City of Portland, Maine - Building or Use Permit Application
 389 Congress Street, 04101 Tel: (207) 874-8703, Fax: (207) 874-8716

Permit No: 04-0877	Issue Date: JUN 23 2004	QBL: 339 B021001
-----------------------	----------------------------	---------------------

Past Use: Single Family	Proposed Use: Single Family w/24' x 52" above ground pool & 12' x 42' deck on grade	Permit Fee: \$57.00	Cost of Work: \$3,400.00	CEO District: 5
-----------------------------------	---	-------------------------------	------------------------------------	---------------------------

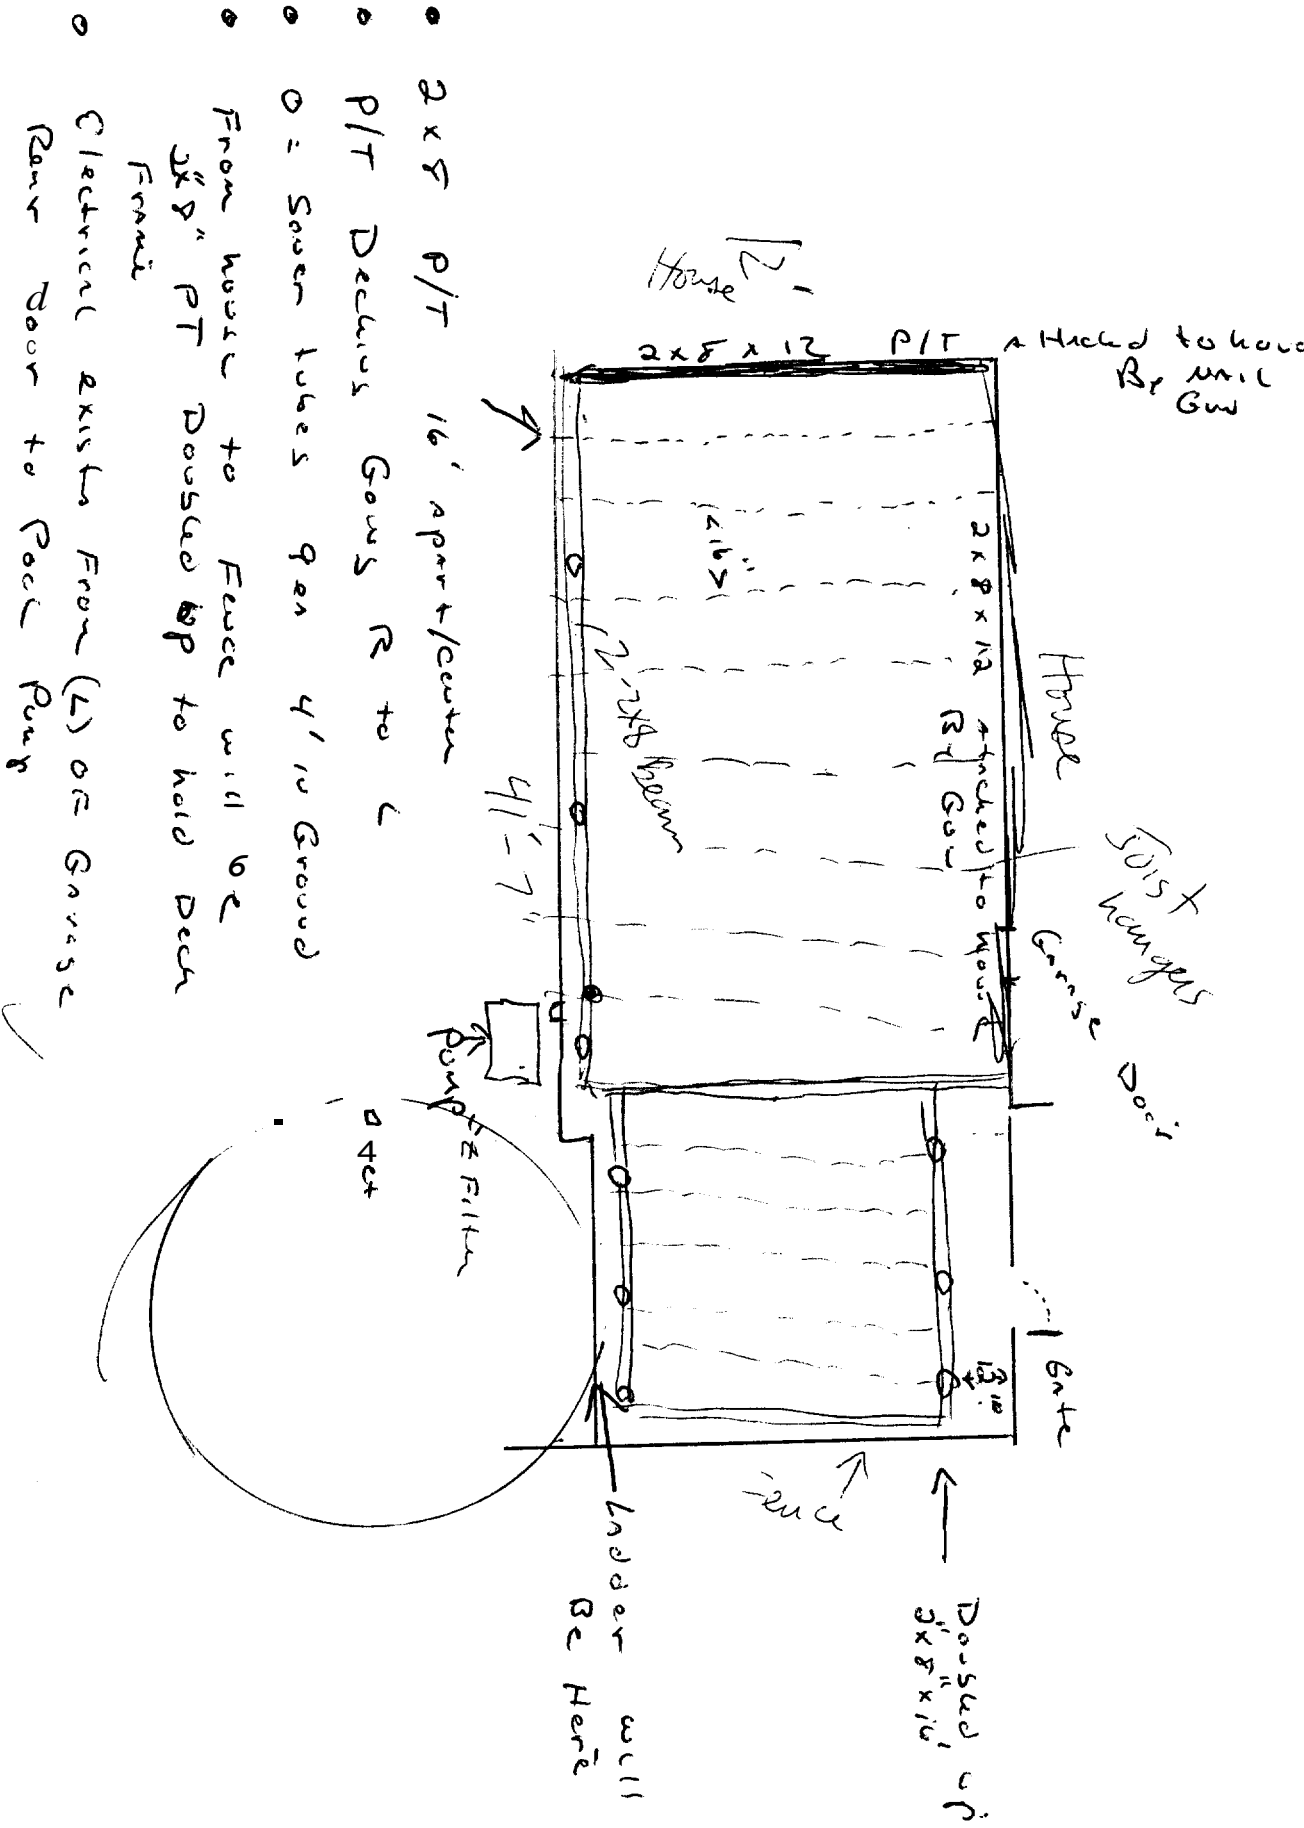
Dept: Building	Status: Approved	Reviewer: Jeanine Bourke	Approval Date: 06/28/2004
Note:	Ok to Issue: <input checked="" type="checkbox"/>		
1) K. Carroll responded to a complaint, sona tubes already installed @ 4' + per owner			
2) Ladder barrier protection must be installed per Sec. 421 of the 1999 BOCA code

R3
 10' Req from
 Principal structure
 & Property Lines

Deck:
 Rear 25' Req 34' shown
 Side 8' Req 28' shown

If over
 15 1/2" will need
 36" Ht guardrail
 4" space on balusters
